Your reference :  
Our reference : SF19/87530; DOC19/832968  
Contact : Sheridan Ledger; (02) 6333 3800

27 September 2019

**Springvale Water Treatment Project – SSD 7592 - Modification 4**  
**EPA comment on Modification Report**

Figure 1 - Thompsons Creek Reservoir operating levels

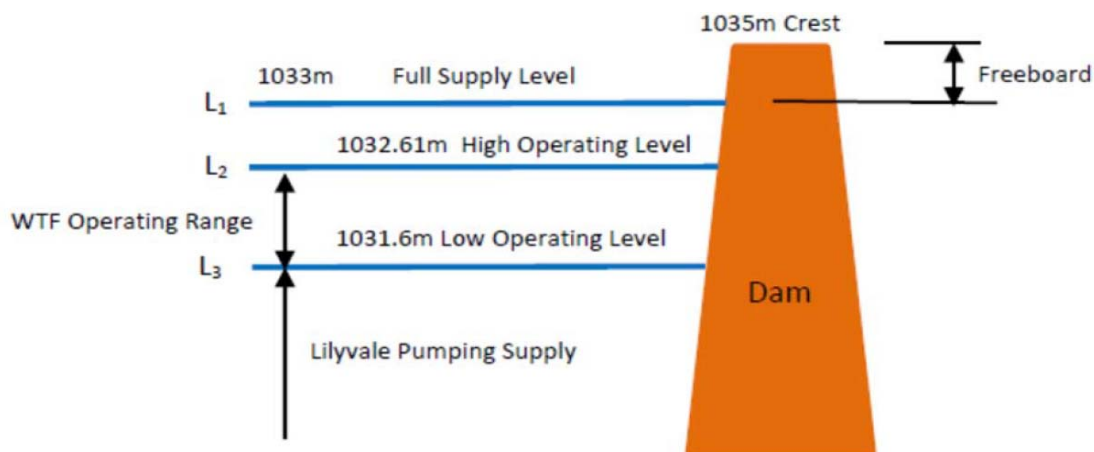
Section 3.2.5 of Appendix A of the Report provides that “*results demonstrate that overflows are not expected to occur even under the wettest of conditions for the Approved and Proposed scenarios*”. Noting the current water requirements of the Mount Piper Power Station (MPPS), which are directly related to power generation, and the assumptions made in the Report, the EPA considers there is a potential risk that overflows, or the need for controlled discharges, may occur.

1. Develop a contingency strategy to account for the potential changes in water volumes in TCR as a result of changes in water use by MPPS because of its current reduced operation.

This contingency strategy should consider options for management of water that may be in excess of what can be safely stored in TCR and could include discharge, increases in environmental flow and/or continued use of desalinisation at Angus Place.
